DELEGATED HOUSEHOLDER DECISION

Item No.	Report of the Head of Development Management and Building Control		
Address:	3 ACACIA AVENUE RUISLIP		
Development:	Construction of a part single-storey, part two-storey wraparound extension to the side and rear following the demolition of the existing garage		
LBH Ref Nos:	43839/APP/2024/3274		
Drawing Nos:	Existing Elevations & Floor Plans 201 B 202 B 300 400		
Date Plans received:	16-12-24	Date(s) of Amendments(s):	22-01-25
Date Application valid	16-12-24		22-01-25 22-01-25

Drawing Title:  
PROPOSED  
ELEVATIONS  
SCALE: 1:50 @ A1  
Drawn by: ML  
Drawing no: 202 rev B  
Date: Dec 2024

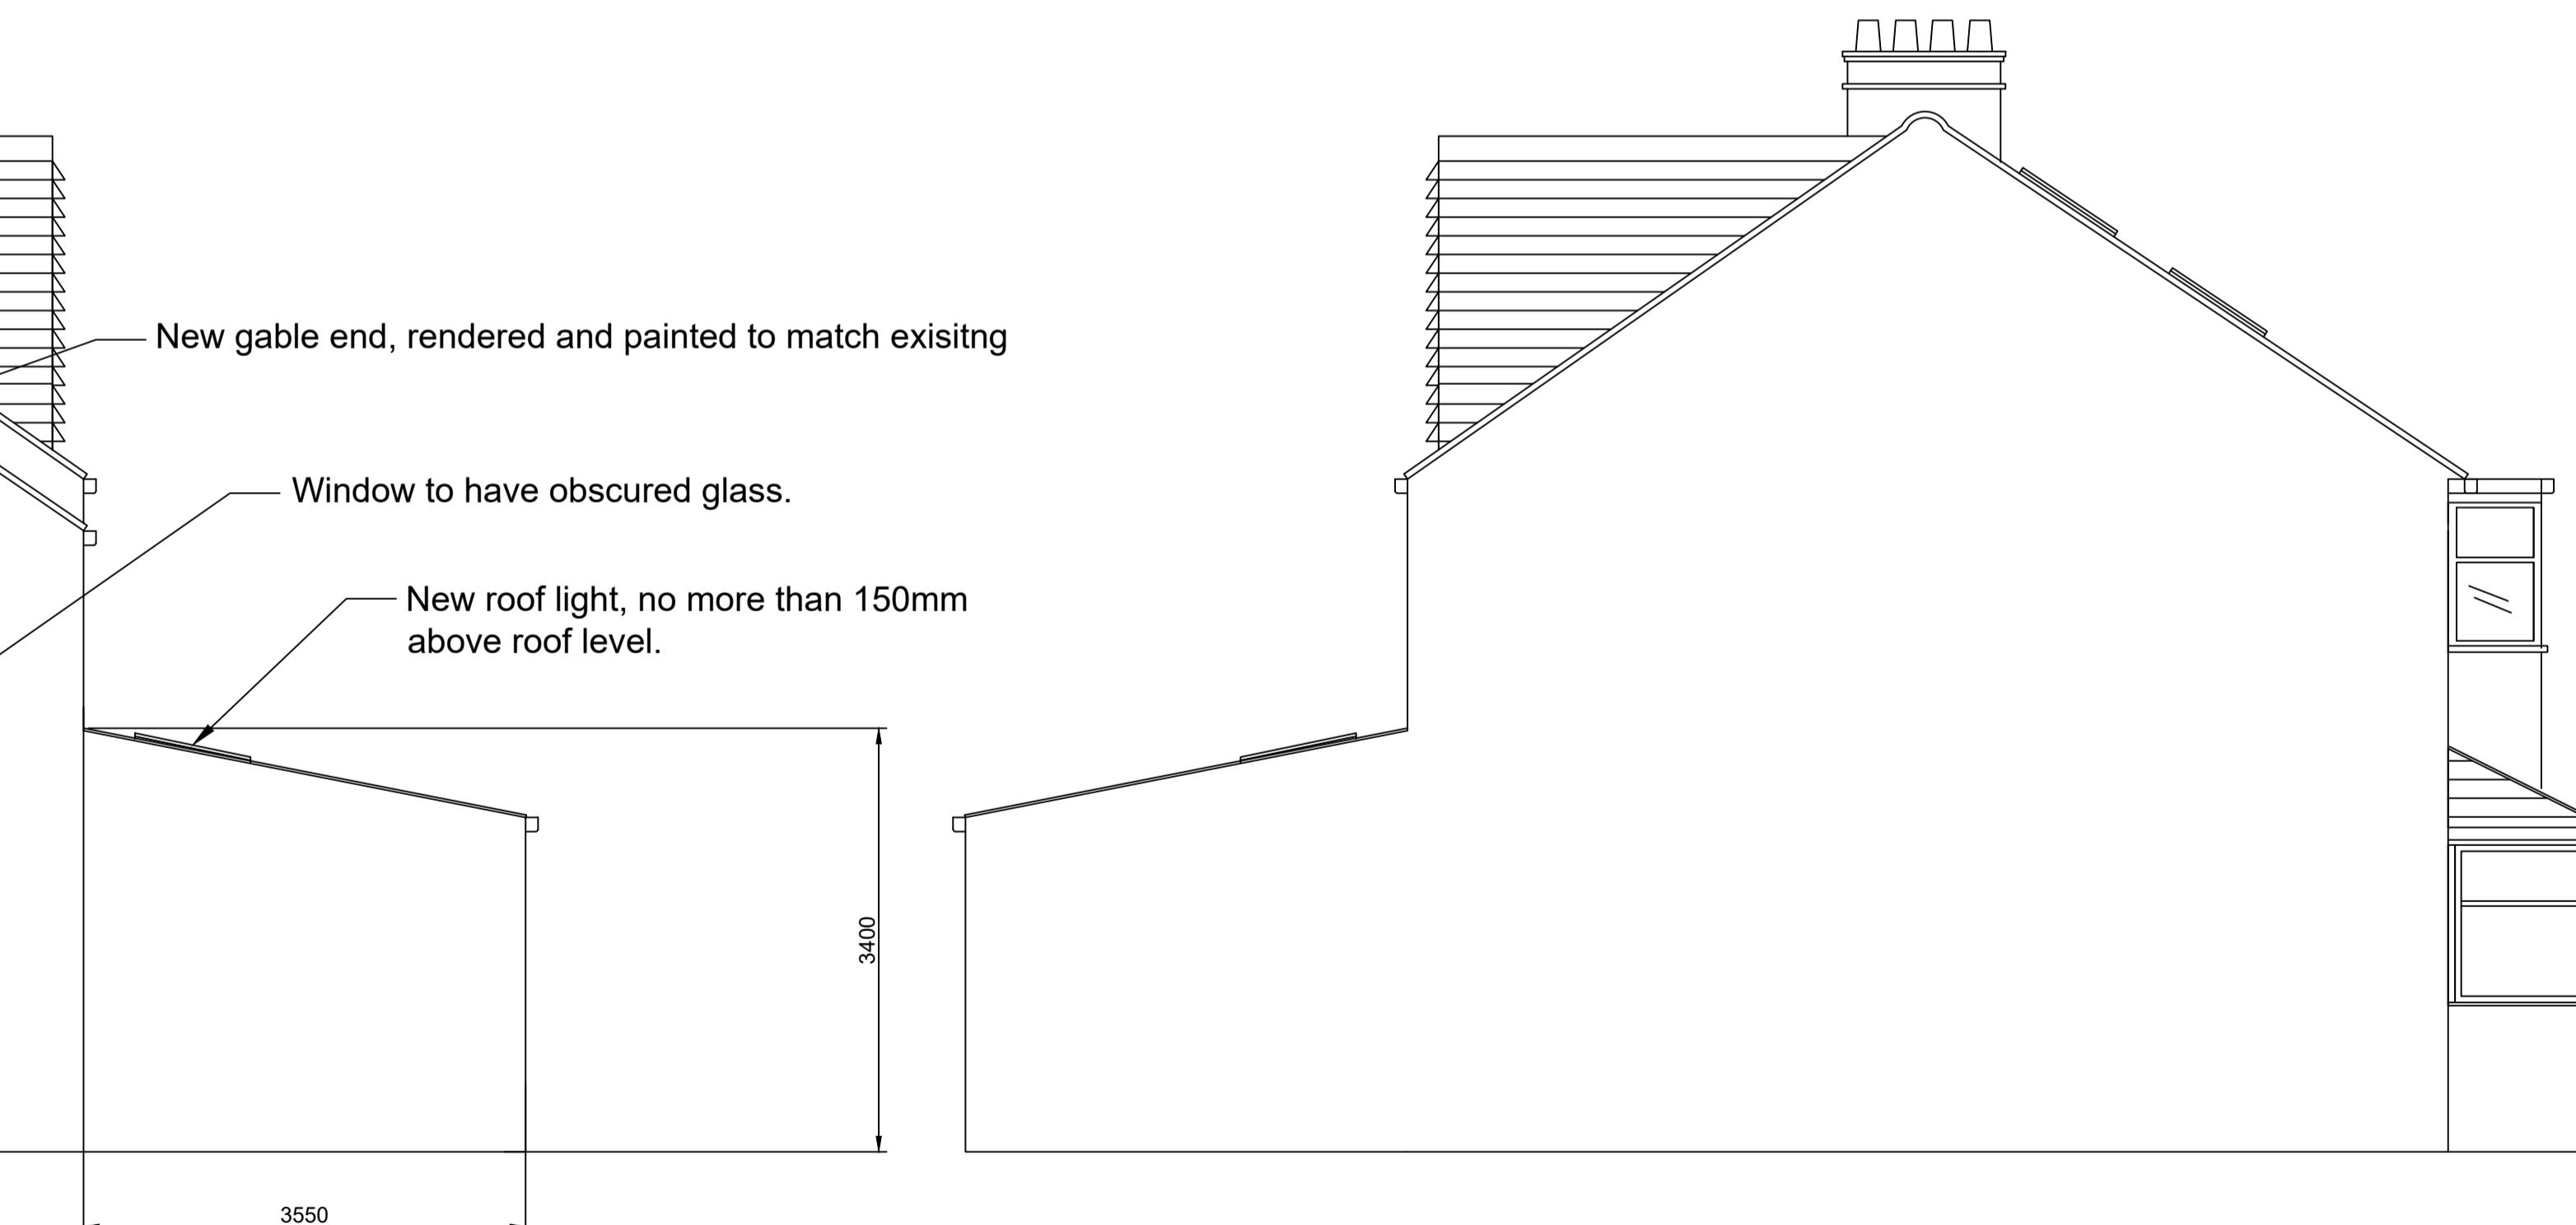
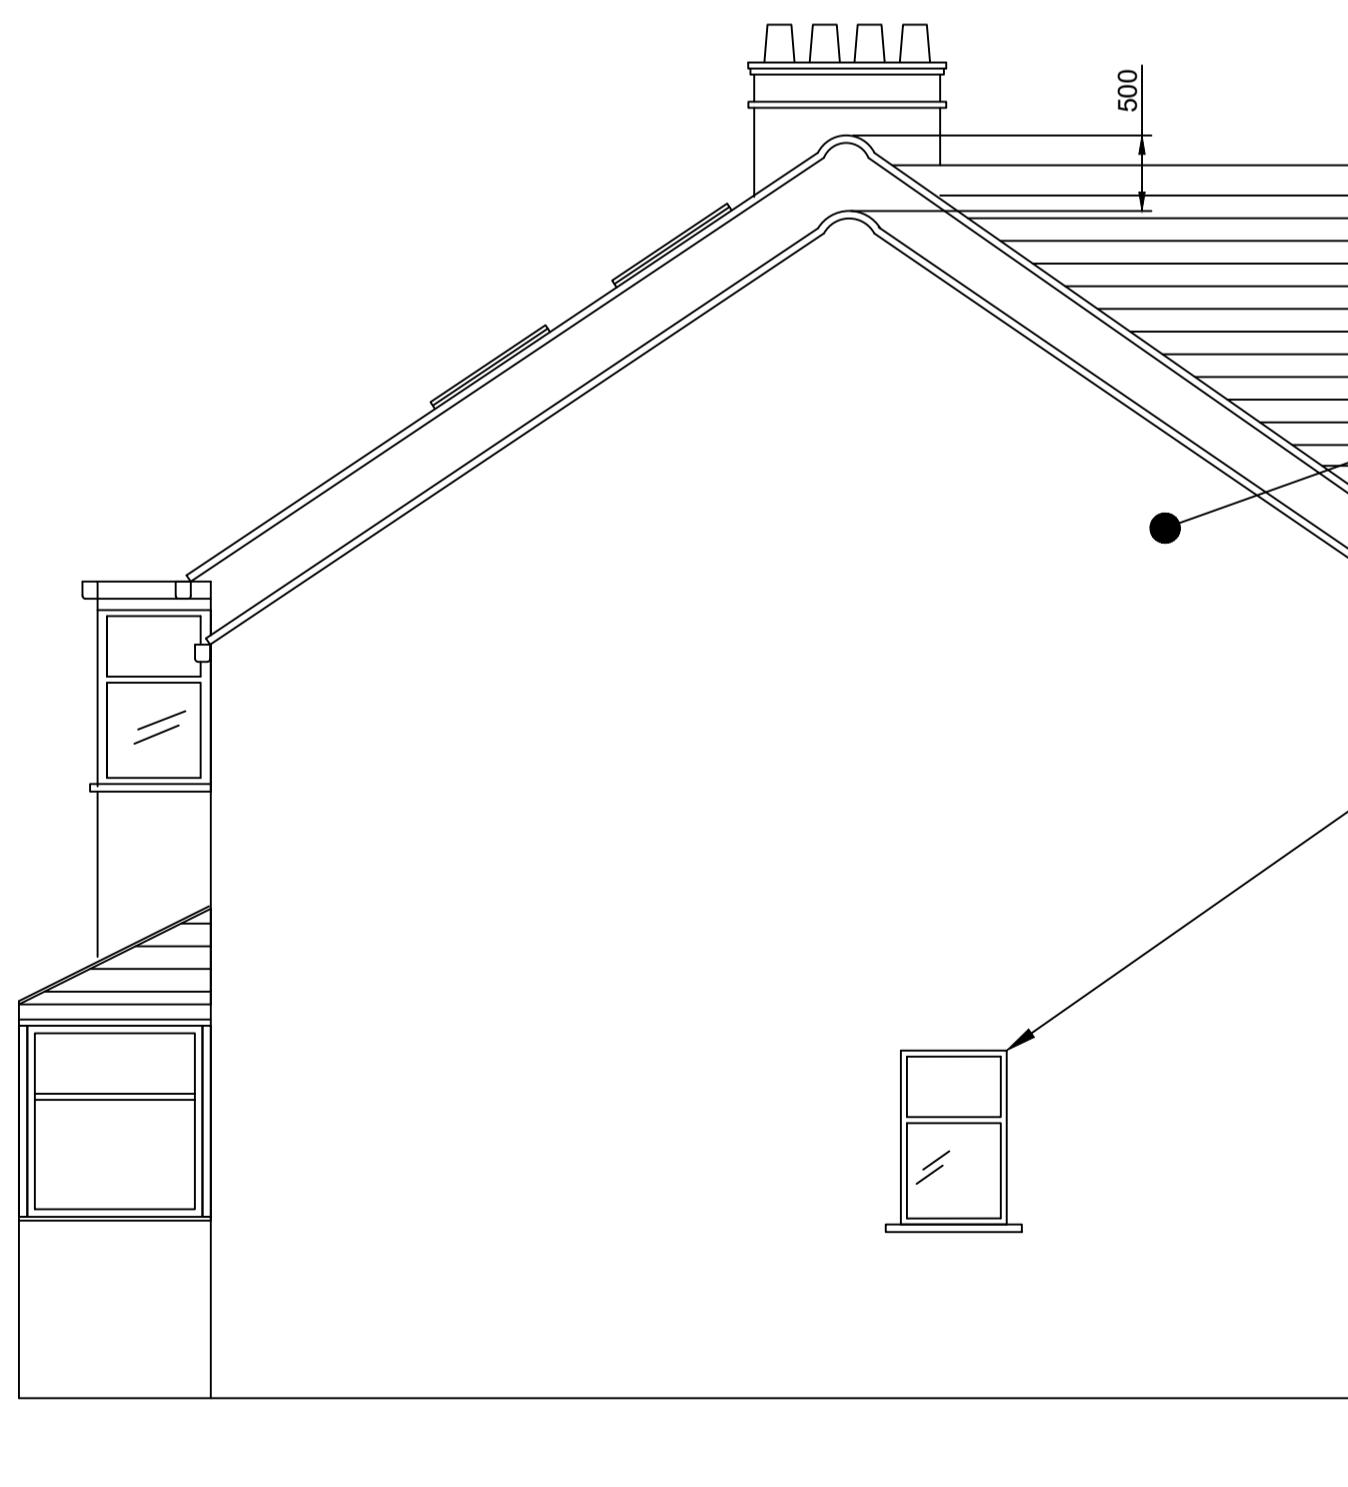
The two-storey side extension was originally proposed to be constructed on the side boundary; however, after receiving feedback from the local authority, the applicant submitted an amended scheme with the extension set in 1m from the side boundary in accordance with Policy DMHD 1. The extension would, therefore, be less than half the width of the original property and set back 1m from the side boundary. This would ensure the extension would be in proportion with the existing dwelling and maintain a good separation from the neighbouring property, avoiding any adverse impacts on the streetscape character. The extension would be set back 700mm from the front projecting bay window, but in this instance, the setback is considered acceptable as it would still be subordinate to the bay window feature and would create a consistent frontage with the existing setback entrance. The extension has been designed with a lower roof profile than the original dwelling, ensuring it would be subordinate to the original dwelling.

The 3.55m-depth and 3.4m tall pitched-roof single-storey rear extension complies with Policy DMHD 1 and is acceptable.

The proposed side extension would be visible to 5 Acacia Avenue, but the amended proposal includes a setback of 1m from the shared side boundary in compliance with Policy DMHD 1, addressing previous concerns over dominance and loss of daylight to the neighbour. The two-storey extension would not extend past the existing rear building line of the application site, which is approximately the same as that of 5 Acacia Avenue, and as a result, would not intrude into the 45-degree line of sight from the rear windows of the neighbour, ensuring it would not be overly dominant or bulky. Given the 1m setback and the fact that the application property is located slightly north of 5 Acacia Avenue, no undue harm would befall the daylight and sunlight access of the neighbouring dwelling. The proposed single-storey rear complies with Policy DMHD 1 with respect to the height and depth of the extension and would be set back 1m from the shared boundary. As a result, the extension would not be overly dominant or bulky to the neighbouring occupiers, nor would it unduly impact daylight & sunlight access to the neighbouring property.
